From: [REDACTED]
To: [A303 Sparkford To Ilchester](#)
Cc: [REDACTED]
Subject: Deadline 8 Submission on behalf of Mr B G Norman
Date: 10 June 2019 22:04:16
Attachments: [Queen Camel High St Traffic Audit Report 16 May 201910062019.pdf](#)
[B G Norman Deadline 8 Submission \(Part 1\) 10 06 2019.pdf](#)
[B G Norman deadline 8 Submission \(Part 2\) 10 06 2019.pdf](#)

Ref: SPIL – APP 001

Deadline 8 submission (part 1)

FIGURE 2.5  
HAZLEGROVE JUNCTION UNDERBRIDGE  
GENERAL ARRANGEMENT

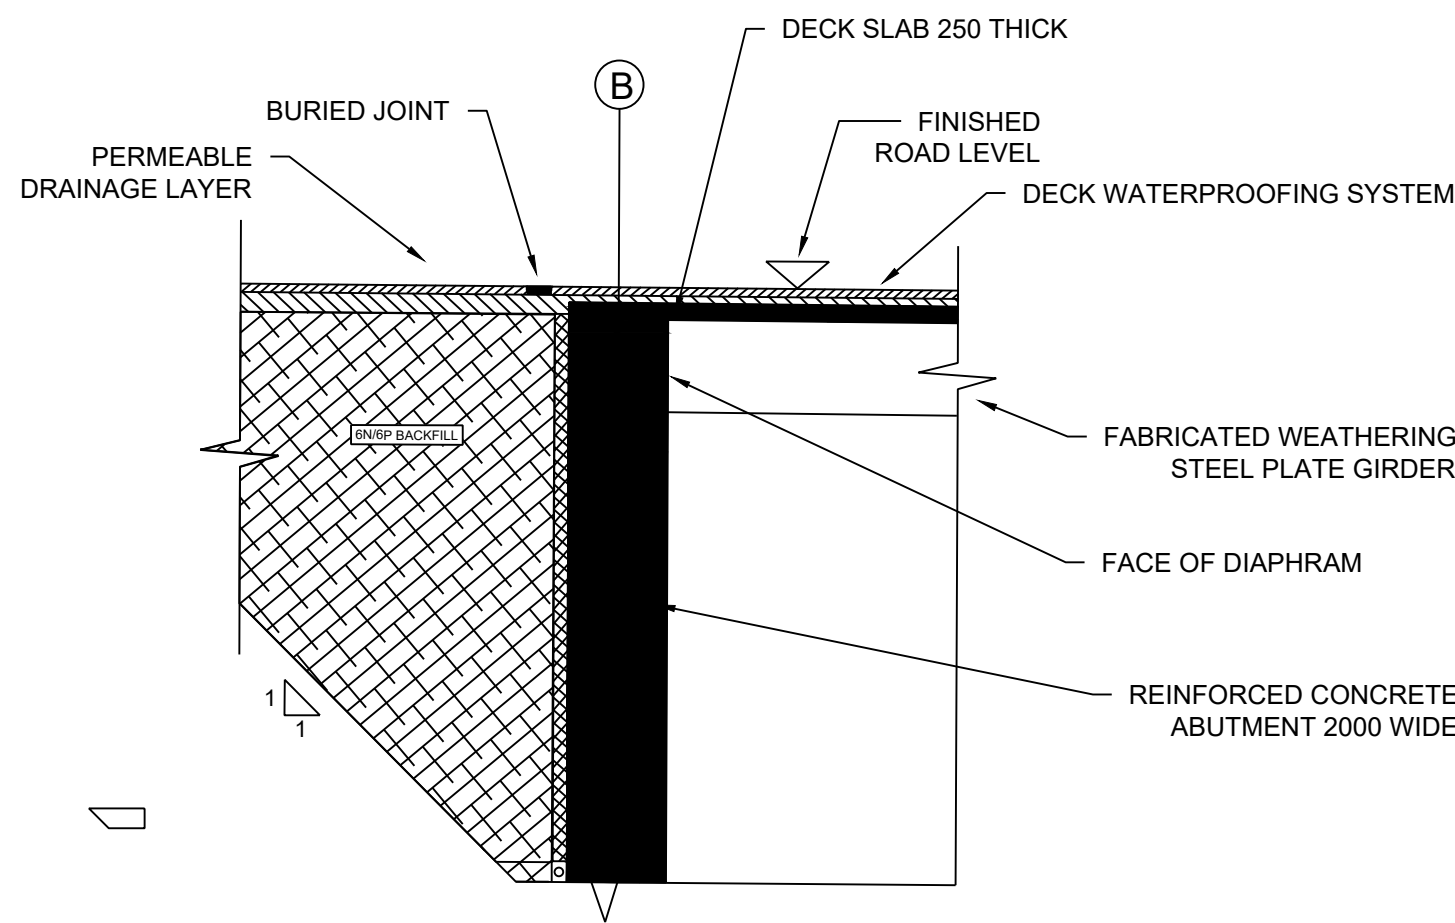
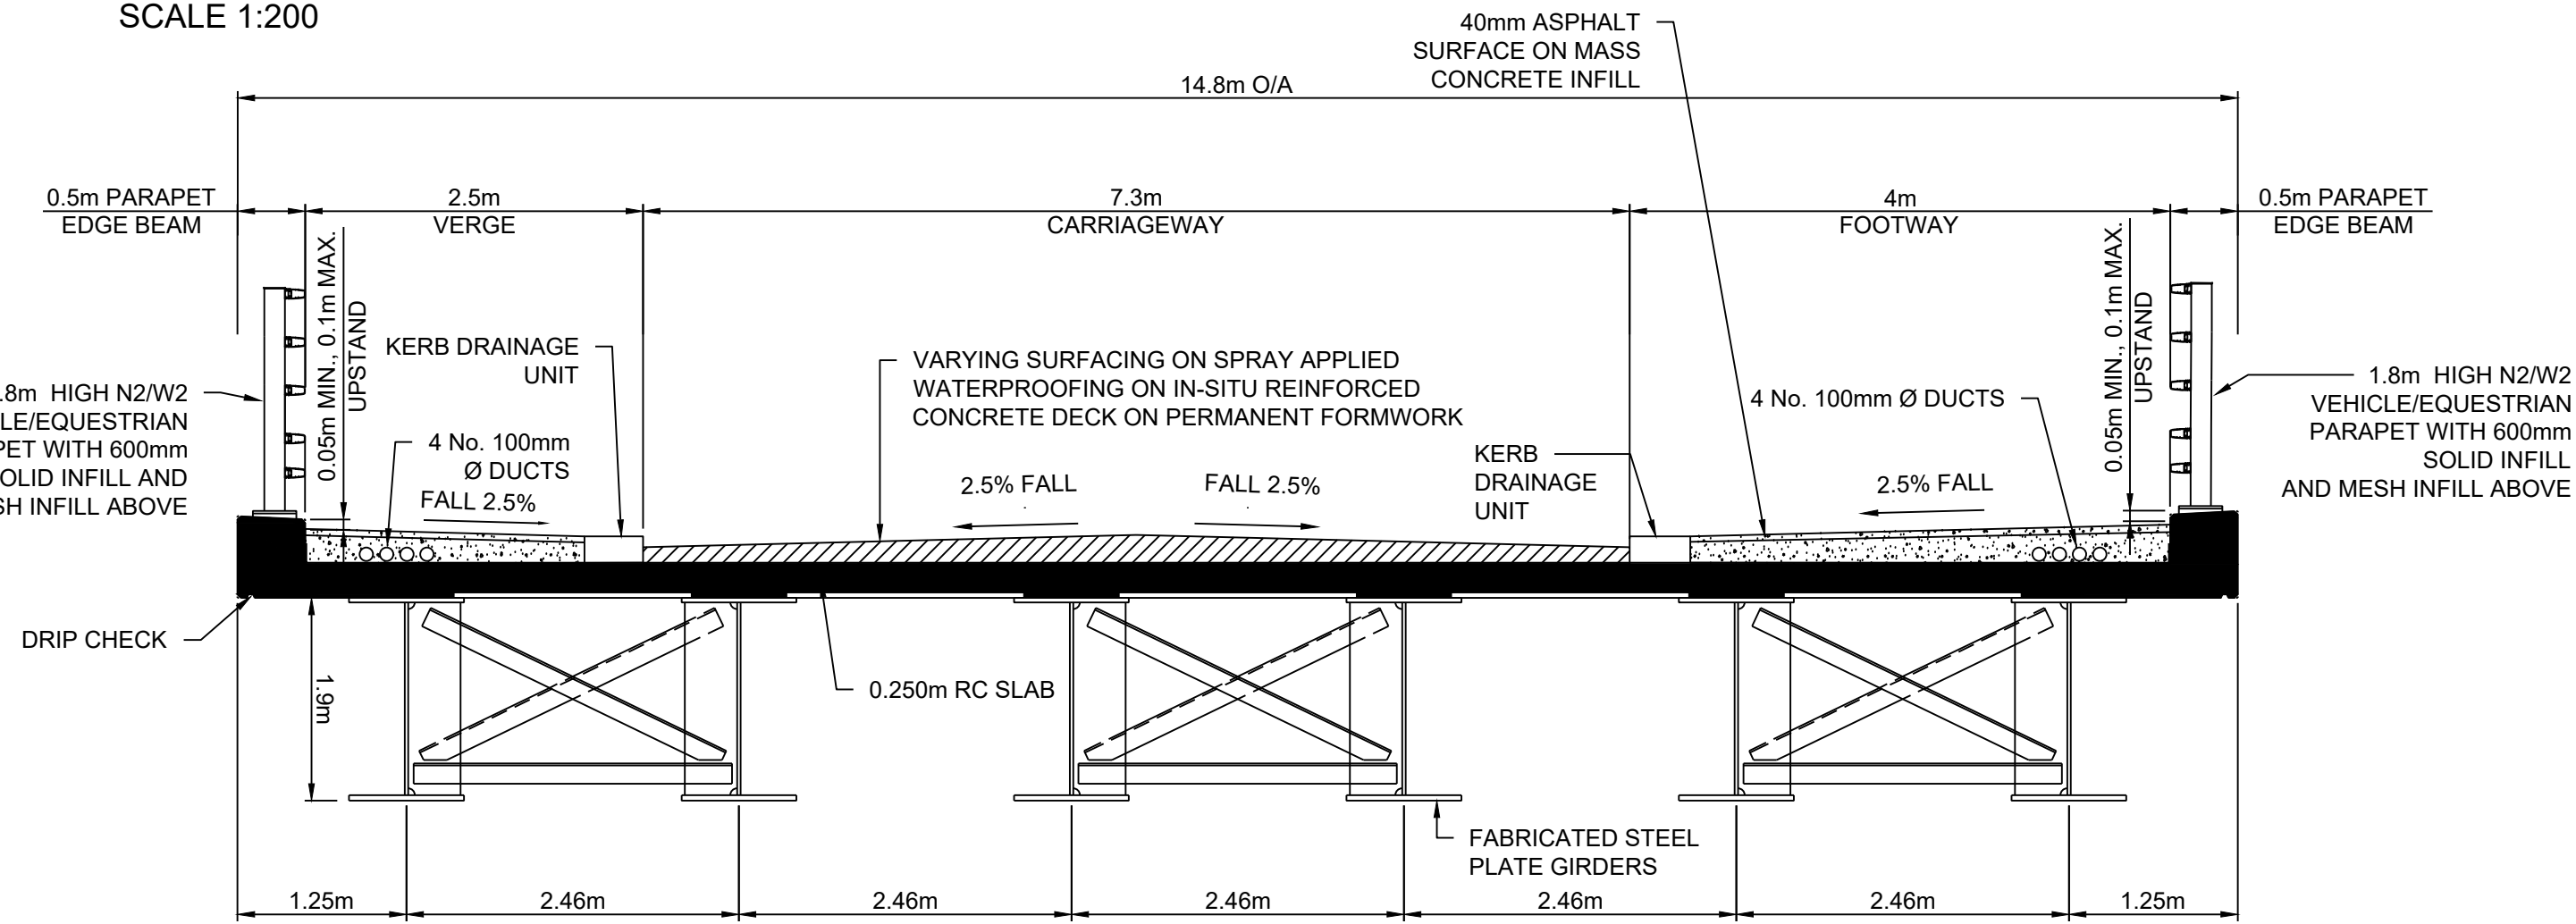
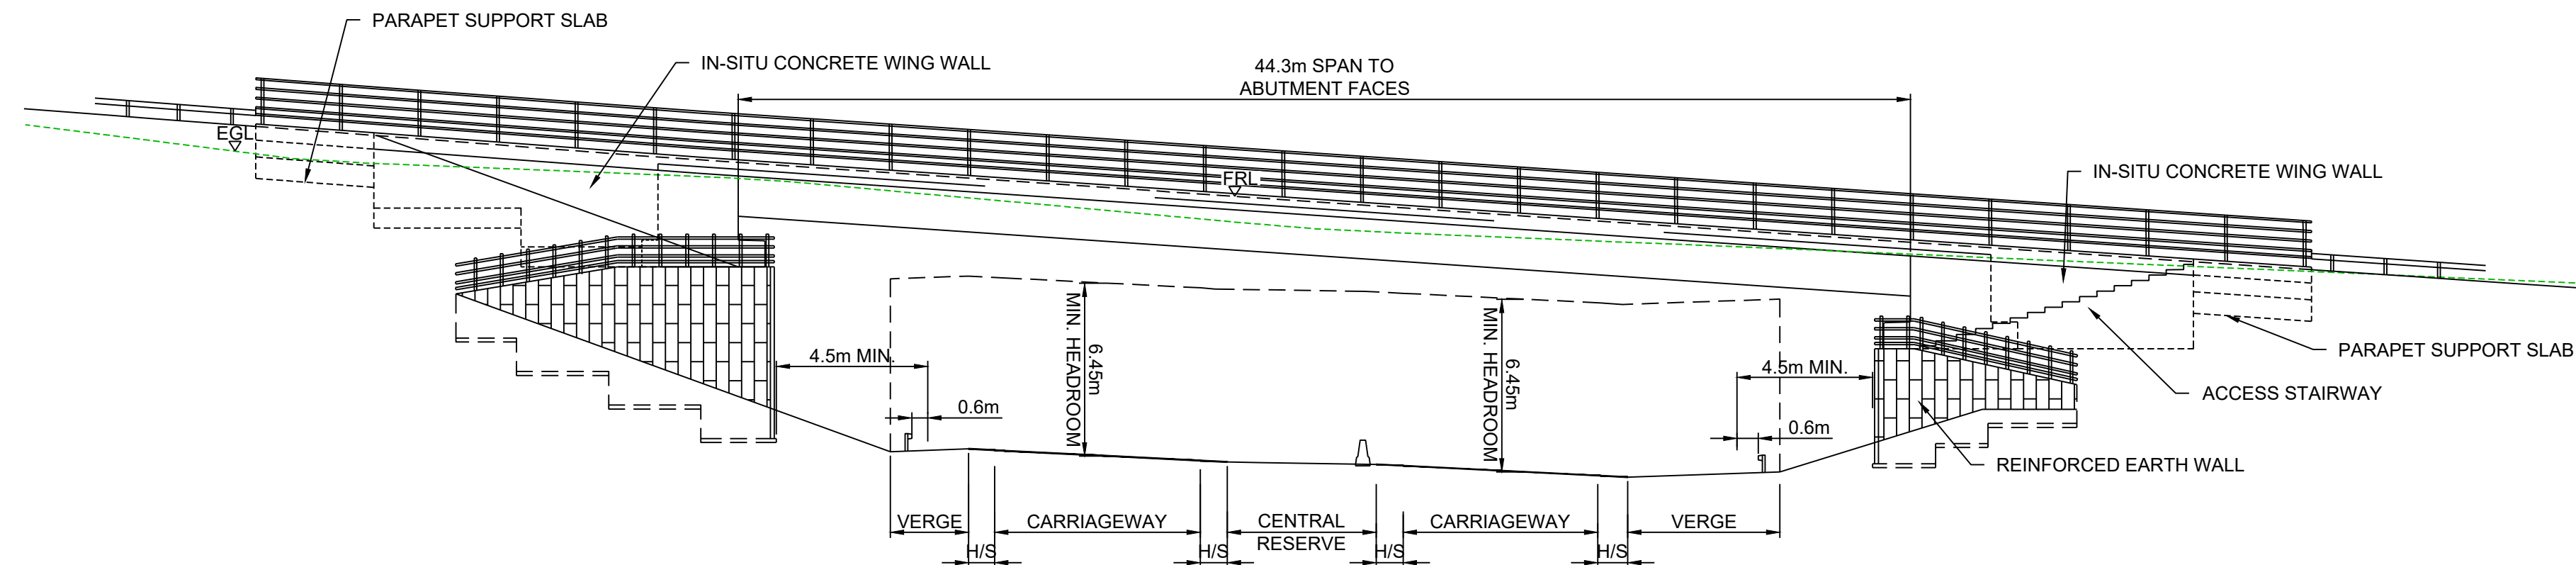
1. There were planning objections to the H.E proposals relating to the design of Hazlegrove Junction from me and the Parish Councils from the outset (and the lack of a parallel road) (Para 63 deals with undue delay).
2. The alternative siting was within the DCO red line boundary.
3. The alternative design was a fully developed concept and in full compliance with the DMR&B and therefore neither inchoate or vague.
4. The obvious and substantial environmental advantages of the alternative siting and design significantly outweighs the design proposed by H.E.
5. The similarity of the situation within the Grade II listed park and garden to the M.O.L. give rise to a presumption that development should not be permitted unless very special circumstances can be demonstrated that clearly outweigh the harm. This has not been proved.

In normal planning appeal cases when substantial parts of the development are not an issue, as the dual carriageway is not, in relation to the DCO. But there are justifiable objections to small elements. It would be normal to give consent subject to conditions requiring changes. In this case to the Hazlegrove Junction. The ponds to avoid the bird strike problem for the RNAS and the parallel road.
